From: Contact Centre (CRM) <contact@ribblevalley.gov.uk>
Sent: 24 December 2023 10:22
To: Planning
Subject: Planning Application Comments - 3/2023/0858 FS-Case-571641113

Planning Application Reference No.: 3/2023/0858

Address of Development: Stanley House, Preston New Road, Mellor, BB27NP

THE GLASS MARQUEE, BLACKBURN – DECKING DETAILS

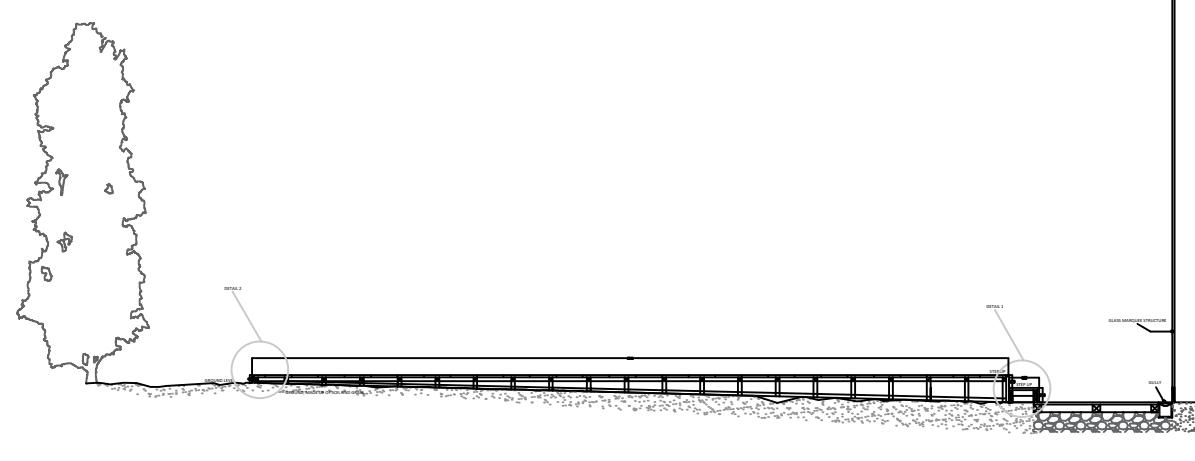
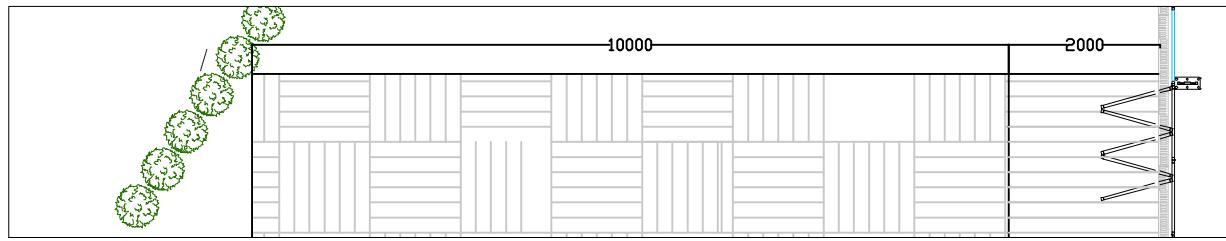
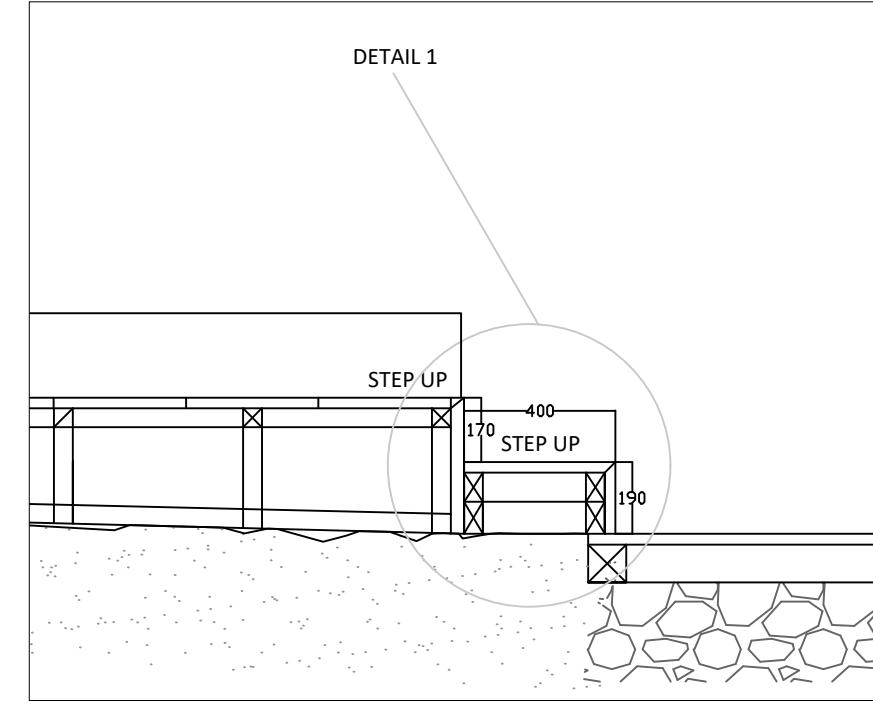
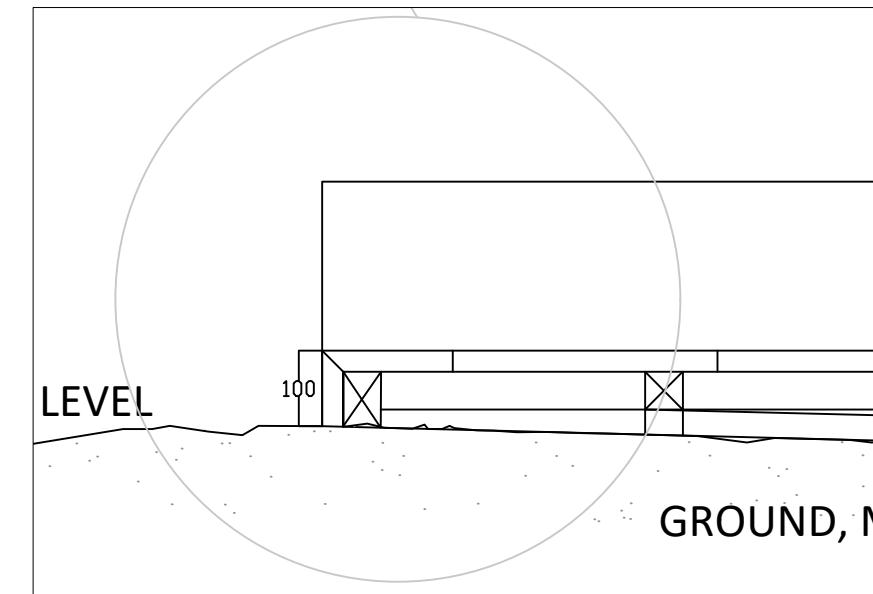
The external decking area does not currently have planning permission & should not be given permission. The licence requires doors & windows to be kept closed. Patrons should not be encouraged, or permitted, via planning consent to use external areas because this is likely to undermine the licence conditions imposed for the purpose of preventing public nuisance.

As for the raised decking, then surely this must represent a threat to the Public Nuisance conditions that formed the basis of the Grant of Licence, as detailed by your colleagues in Environmental Health. An outdoor decking area for event purposes is intrinsically linked to the main marquee building, as shown in page 5 of the Applicant's Statement. Access to the decking would allow noise to escape the main building and the limiters to be totally ineffective and be totally in contravention to the guidelines issued and the principles therein. This decking is not new and been in existence for almost a year but previously formed the base for 2 self contained structures as opposed to what is now proposed as an outdoor extension.
